**APPLICATION REFERENCE NO: 147270**

**PROPOSAL: PINS consultation on behalf of the Secretary of State for its opinion (a scoping Opinion) as to the information to be provided in an Environmental Statement – EN020034**

**LOCATION: North Humber to High Marnham**

**Creator:** JH | **Date:** 31/07/2023 | **Checker:** DF | **Date:** 31/07/2023 | **Approver:** CB | **Date:** 31/07/2023

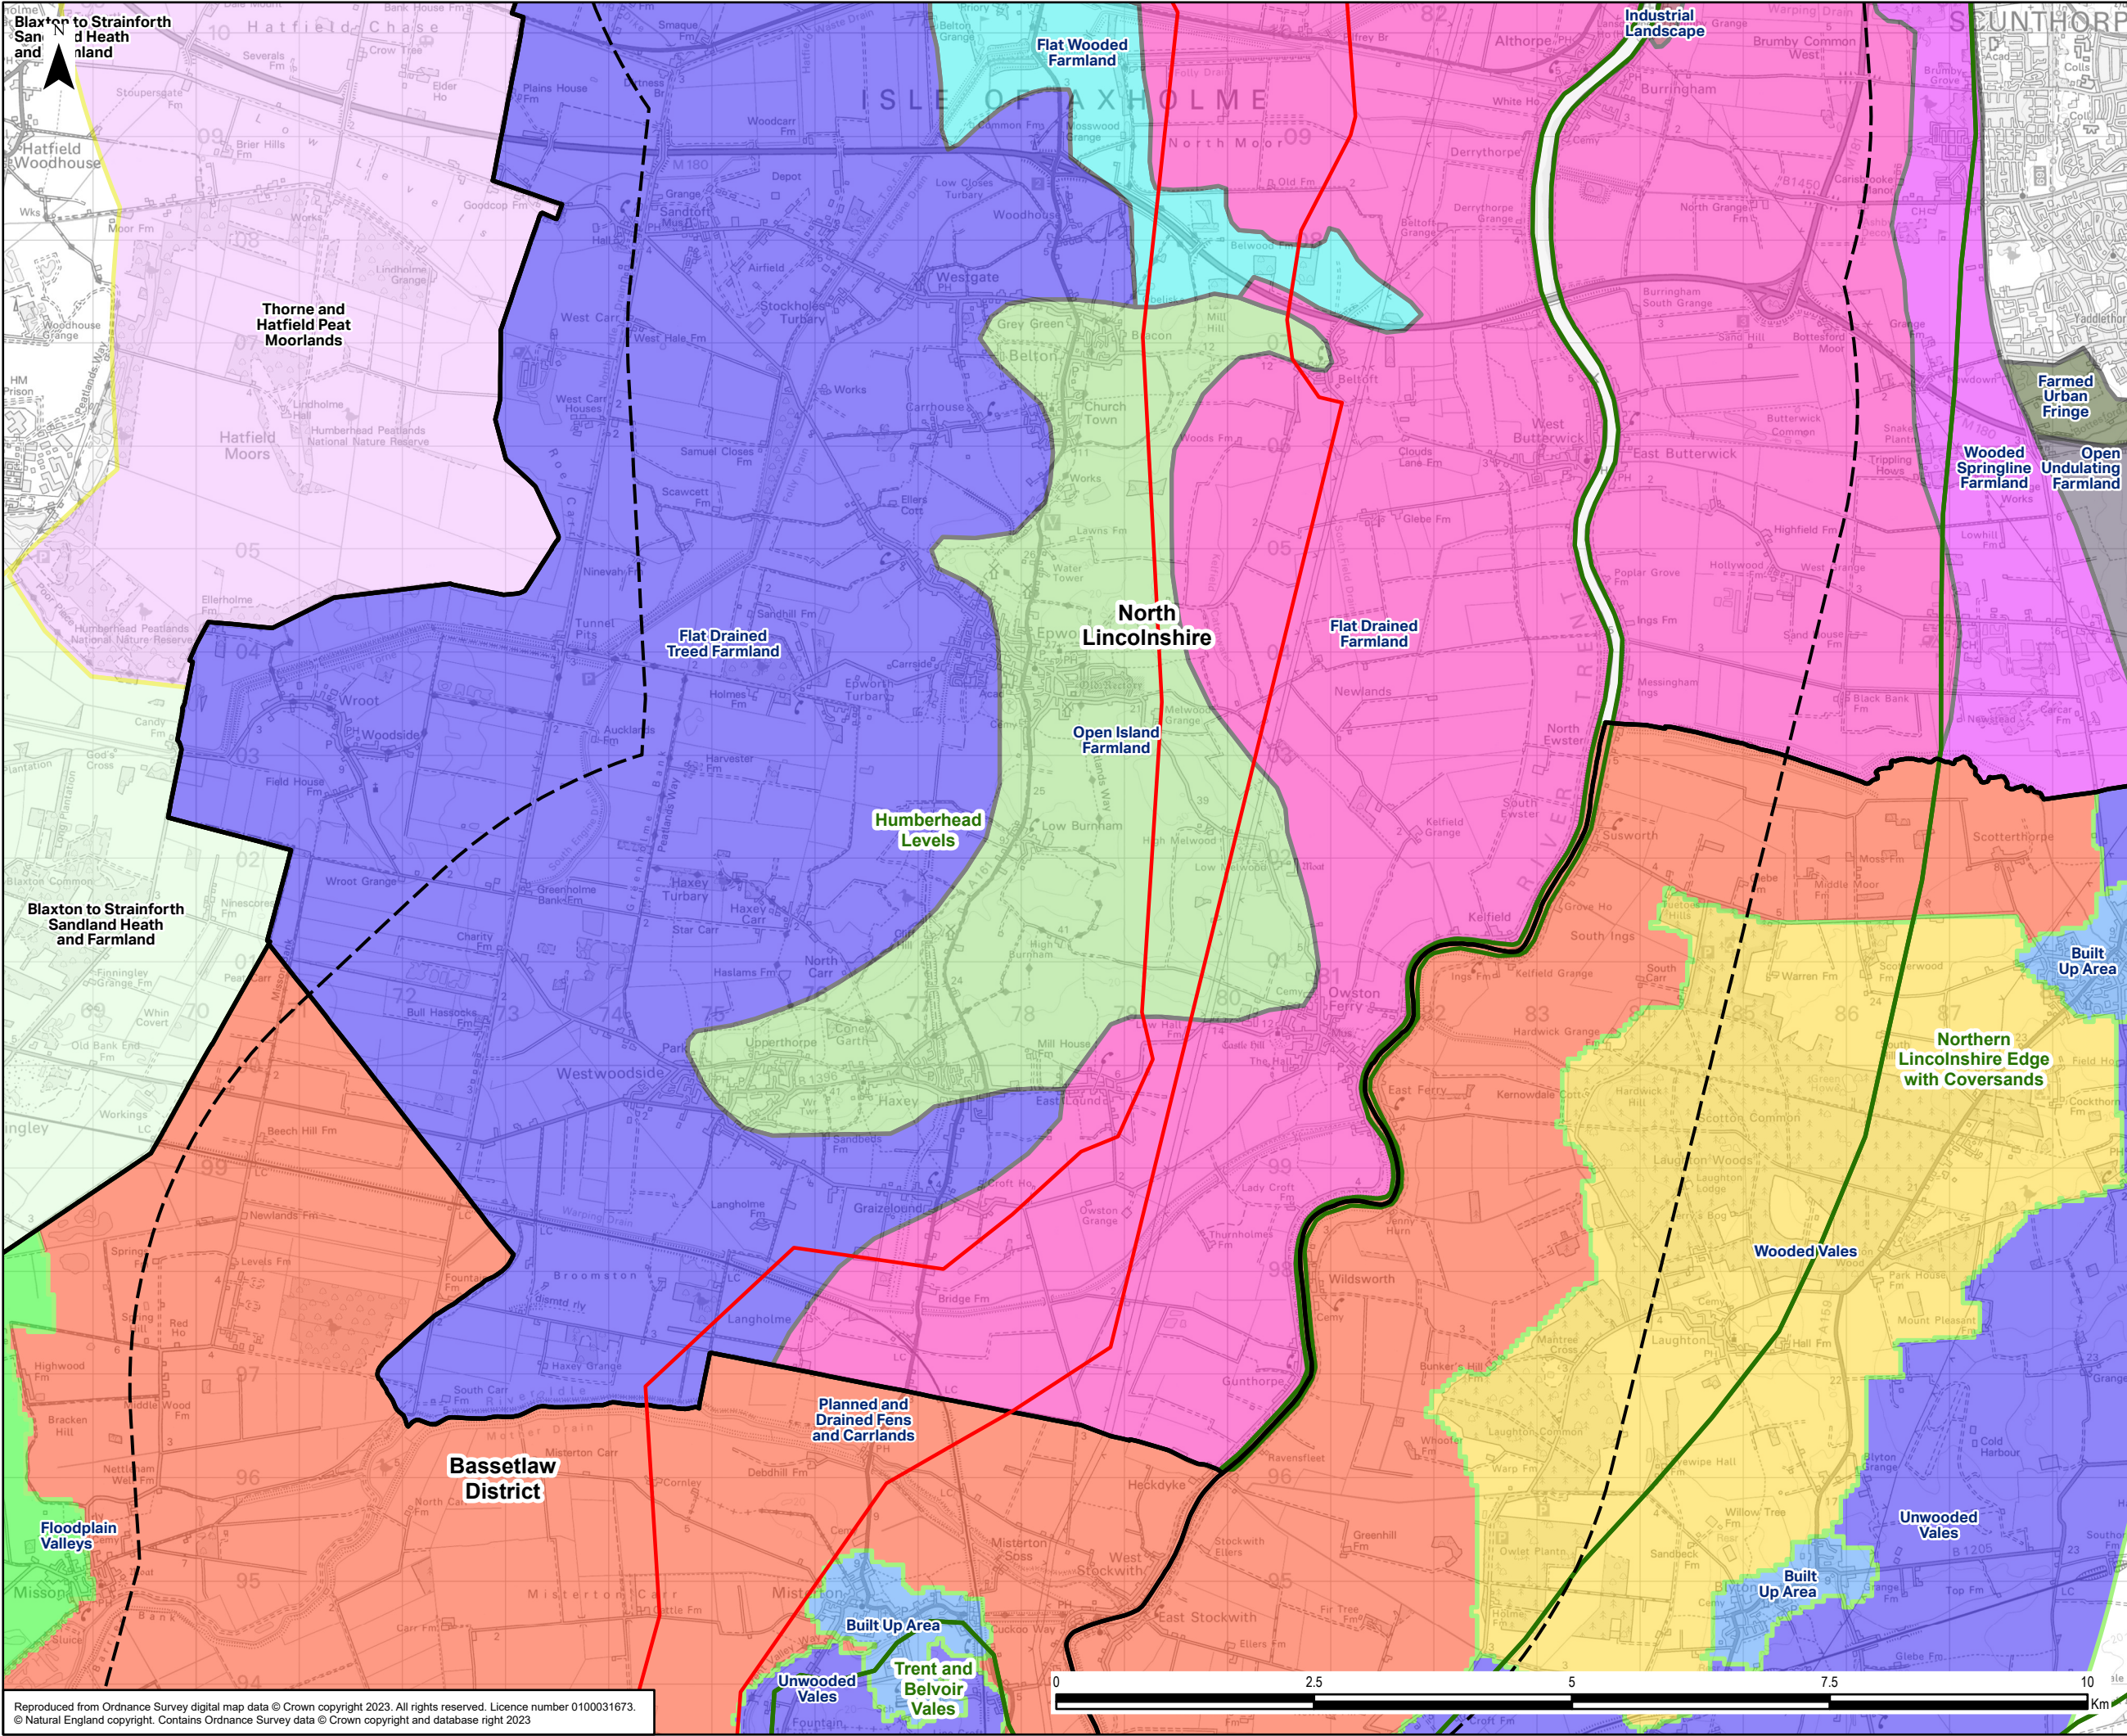
The approach to the LVIA not referencing National Character Areas (NCAs) and favouring Local Character Areas (LCA) is understood but the purpose of National Character Areas is to provide an overall picture of the character and appearance of an area at a larger scale. Given the nature and scale of the project, the lack of specific consideration to NCAs is concerning and it is the view of the Local Planning Authority that these should be **scoped in** to the final ES. The LVIA should also **scope in** the potential impacts (if any) on LCAs within West Lindsey. It is agreed that the Lincolnshire Wolds can be scoped out.

All relevant NCAs/LCAs within West Lindsey should be **scoped in** to the ES alongside consideration of all relevant development plan policies, including Neighbourhood Plans. This alongside Chapter 9 are the most important considerations to the Local Planning Authority and should be given an appropriate level of consideration.
